**Wandsworth Borough Council
Response to the Examination Panel's first set of questions.**

PINS Reference Number: WWW010001

Figure 1.1 Kirtling Street: Site context and location plan

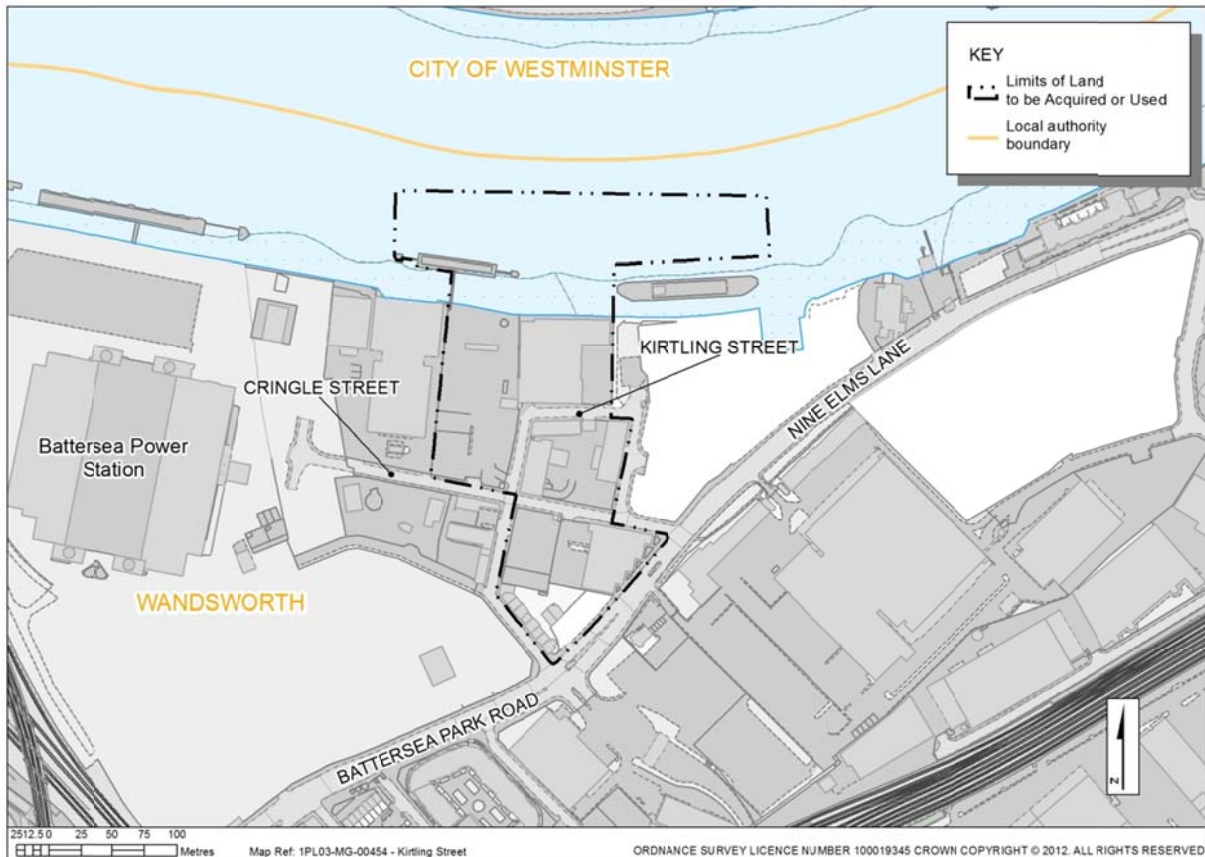
Residential properties including Elm Quay Court, Riverlight and the houseboat communities of nine Elms Pier and Tideway Village in Tideway Dock are located within close proximity to the Tunnel site and the Council is concerned about the effect that potential noise would have on residential amenity.

The planning statements for Kirtling Street and Heathwall pumping station imply that the Riverlight development should have mitigated the potential impacts of the Thames Tunnel (7.01, Appendix J, paragraph J.5.123 and 7.01 Appendix K, paragraph K.5.108). This issue is of concern to the Council as when the Riverlight development was granted planning permission the Thames Tunnel project was in the initial phase of consultation and the details of potential mitigation levels were not available. The Council considers Thames Water should provide adequate mitigation at source to avoid the need to implement noise mitigation through improved sound insulation to dwellings or the extremity of relocating residents.
